Rosefield Solar Farm

Schedule of Changes to the draft DCO (Tracked)

EN010158/APP/3-1-48-1.5
Revision 405
Change Application
May/June 2026
Rosefield Energyfarm Limited

Schedule of Changes to the draft DCO

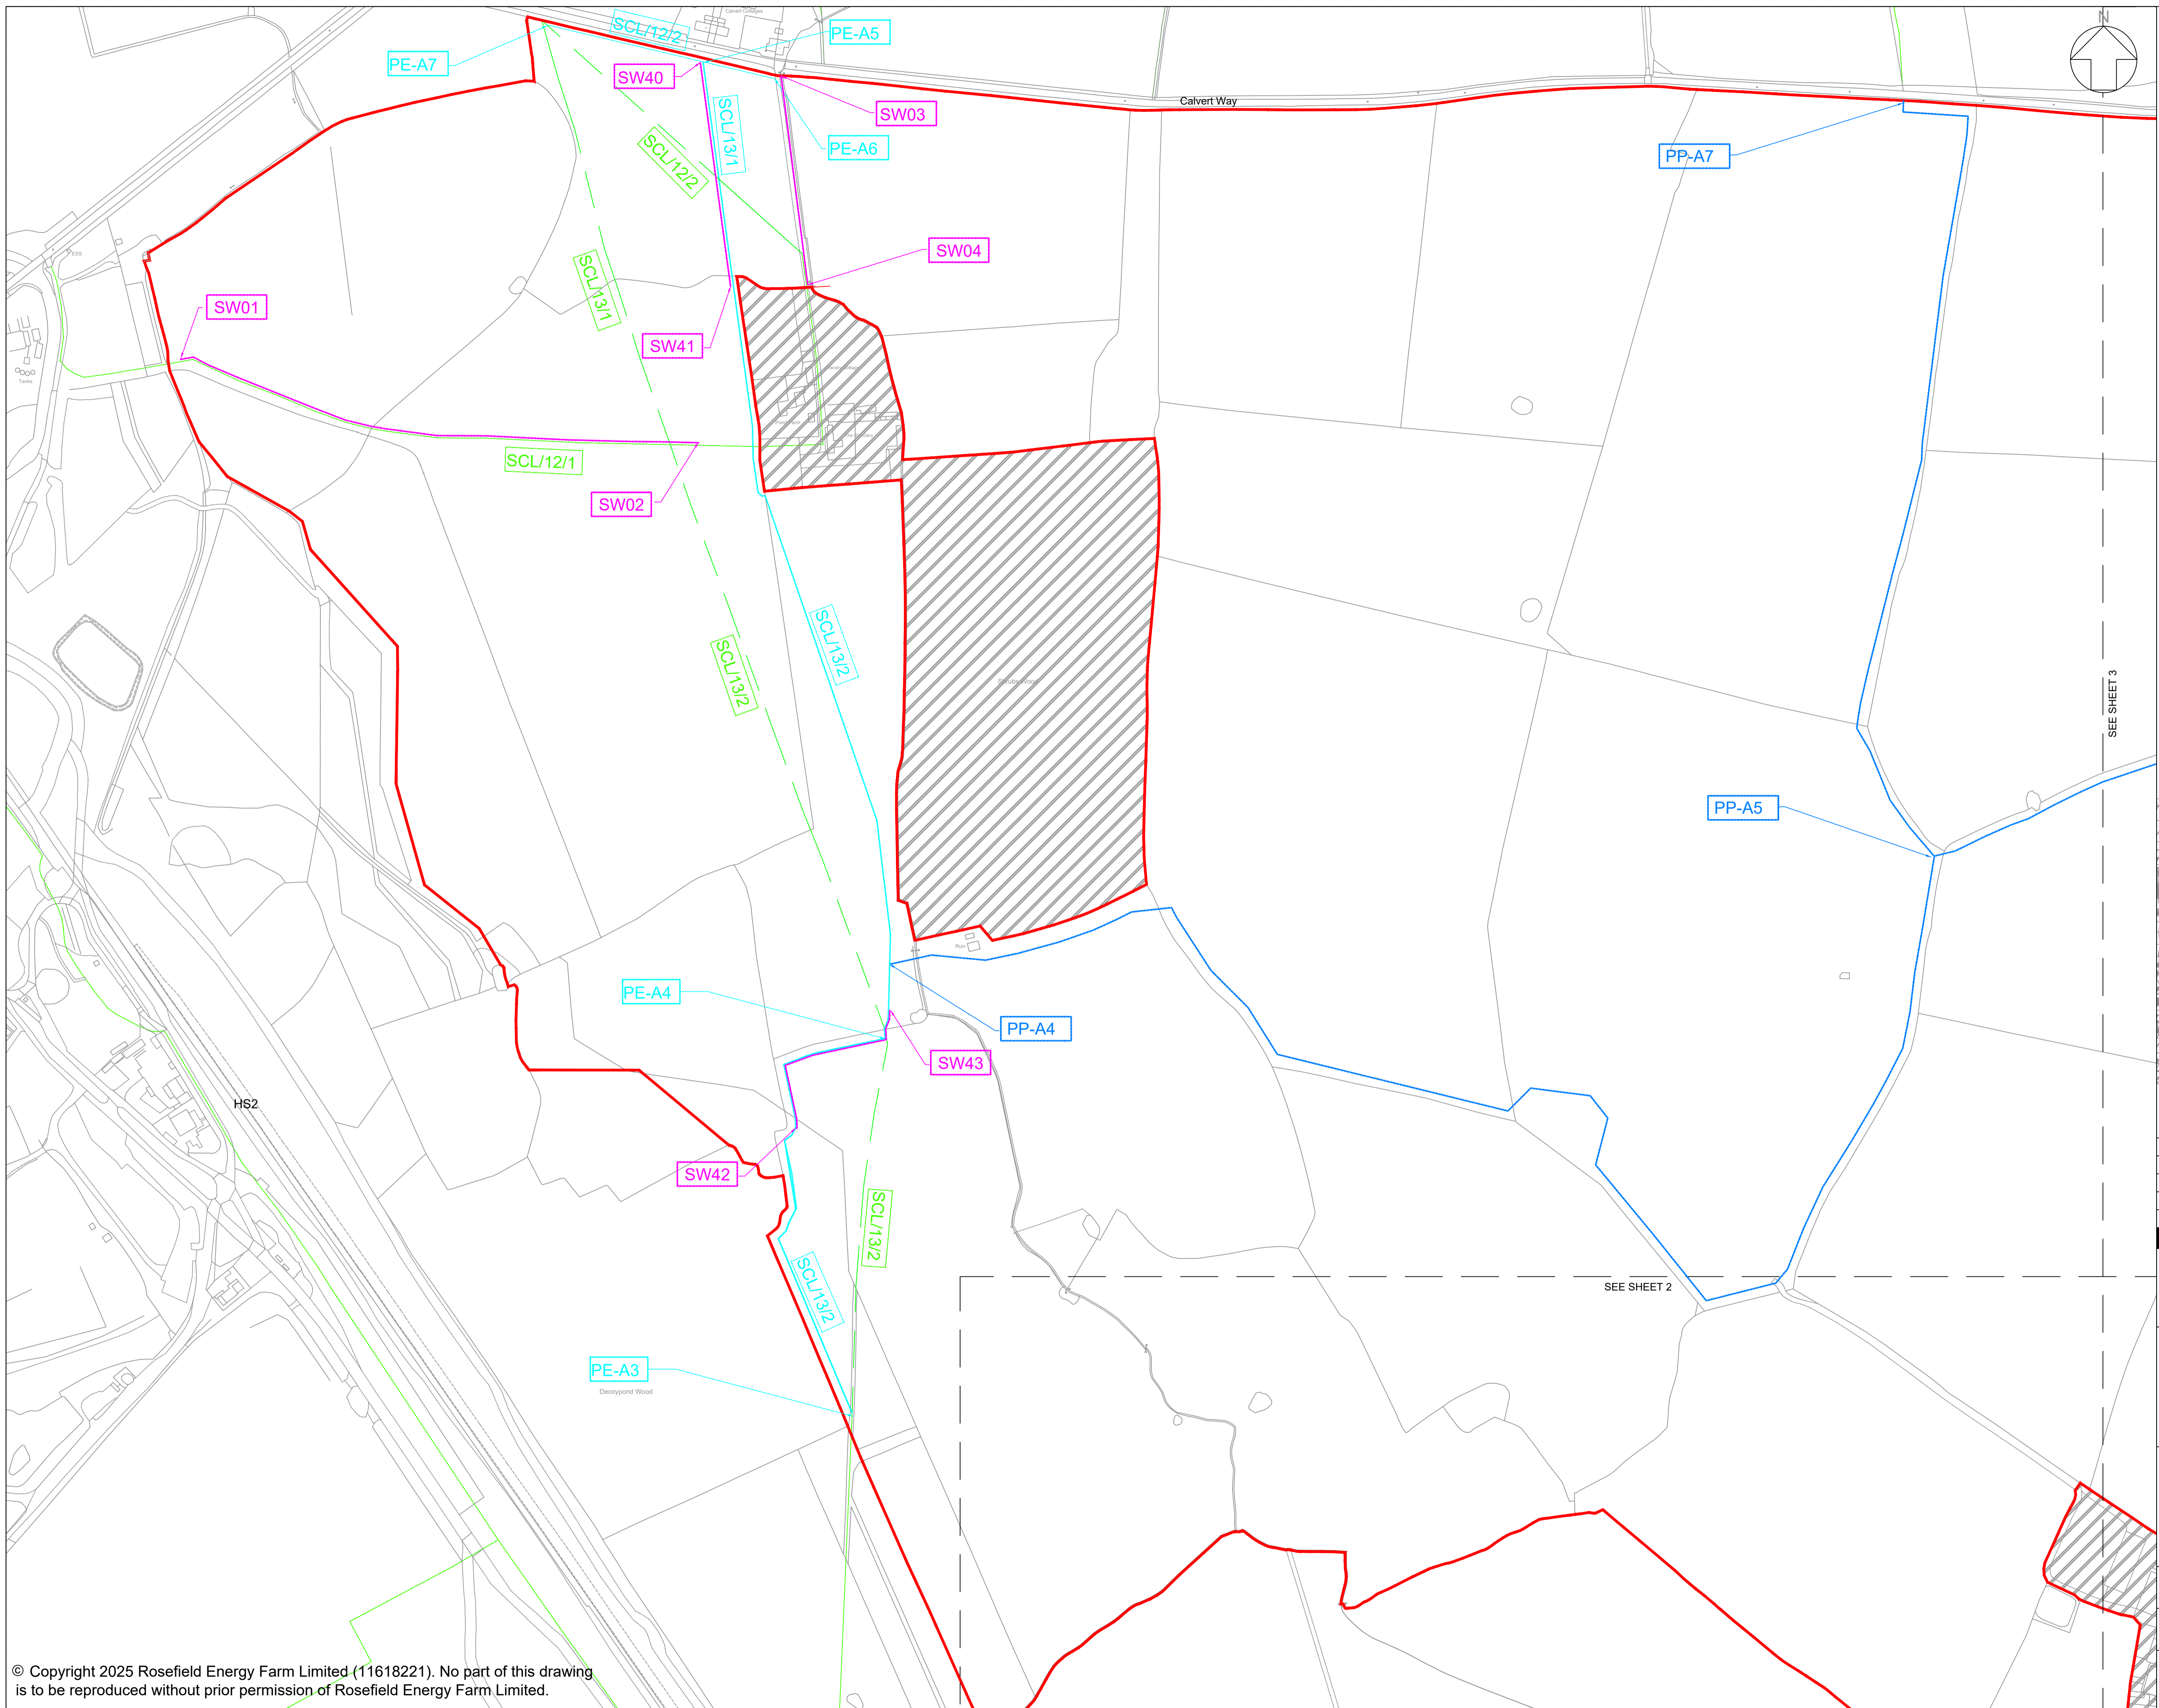
Reference	Change	Reason for Change	Deadline								
	<p>Environment Agency and Anglian Water Services Limited or its successor in function as the relevant water undertaker.</p> <p>(2) The written details under sub-paragraph (1) must be substantially in accordance with the outline drainage strategy.</p> <p>(3) Any approved strategy must be implemented as approved and maintained throughout the construction and operation of the authorised development.</p>	<p>representation [RR-081] and AWS' relevant representation [RR-012], where each requested to be a consultee.</p>									
<p>Schedule 2, Requirement 14 (Operational noise)</p>	<p>14. – (1) No part of Work Nos. 1 to 5 may commence until an operational noise assessment containing details of how the design of that numbered work has incorporated mitigation to ensure the operational noise rating levels as set out in paragraph 13.9.19 of chapter 13 of the environmental statement are complied with for that part has been submitted to and approved by the relevant planning authority.</p>	<p>Addition of reference to more specific operational noise limits on the face of dDCO.</p>	<p>1</p>								
<p>Schedule 6, Part 1 (PRoW to be permanently stopped up and diverted)</p>	<table border="1"> <thead> <tr> <th data-bbox="443 826 725 979"><i>(1) Area</i></th> <th data-bbox="725 826 1008 979"><i>(2) Public right of way to be stopped up</i></th> <th data-bbox="1008 826 1290 979"><i>(3) Extent of stopping up</i></th> <th data-bbox="1290 826 1572 979"><i>(4) New public right of way to be substituted / provided</i></th> </tr> </thead> <tbody> <tr> <td data-bbox="443 979 725 1319"> <p>District of Buckinghamshire</p> </td> <td data-bbox="725 979 1008 1319"> <p>SCL/12/2</p> </td> <td data-bbox="1008 979 1290 1319"> <p>For a distance of 320 190 metres between points PE-A7 PE-A10 and point SW04 as shown on sheet 1 of the streets, access</p> </td> <td data-bbox="1290 979 1572 1319"> <p>New public footpath to be provided between points PE-A7, PE-A5 and its intersection with SCL/12/1 as shown by a cyan line on sheet 1 of</p> </td> </tr> </tbody> </table>	<i>(1) Area</i>	<i>(2) Public right of way to be stopped up</i>	<i>(3) Extent of stopping up</i>	<i>(4) New public right of way to be substituted / provided</i>	<p>District of Buckinghamshire</p>	<p>SCL/12/2</p>	<p>For a distance of 320 190 metres between points PE-A7 PE-A10 and point SW04 as shown on sheet 1 of the streets, access</p>	<p>New public footpath to be provided between points PE-A7, PE-A5 and its intersection with SCL/12/1 as shown by a cyan line on sheet 1 of</p>	<p>Reduction in extent of stopping up to SCL/12/2 to address Buckinghamshire Council's relevant representation [RR-026] to avoid creation of a 'dead-end'.</p>	<p>1</p>
<i>(1) Area</i>	<i>(2) Public right of way to be stopped up</i>	<i>(3) Extent of stopping up</i>	<i>(4) New public right of way to be substituted / provided</i>								
<p>District of Buckinghamshire</p>	<p>SCL/12/2</p>	<p>For a distance of 320 190 metres between points PE-A7 PE-A10 and point SW04 as shown on sheet 1 of the streets, access</p>	<p>New public footpath to be provided between points PE-A7, PE-A5 and its intersection with SCL/12/1 as shown by a cyan line on sheet 1 of</p>
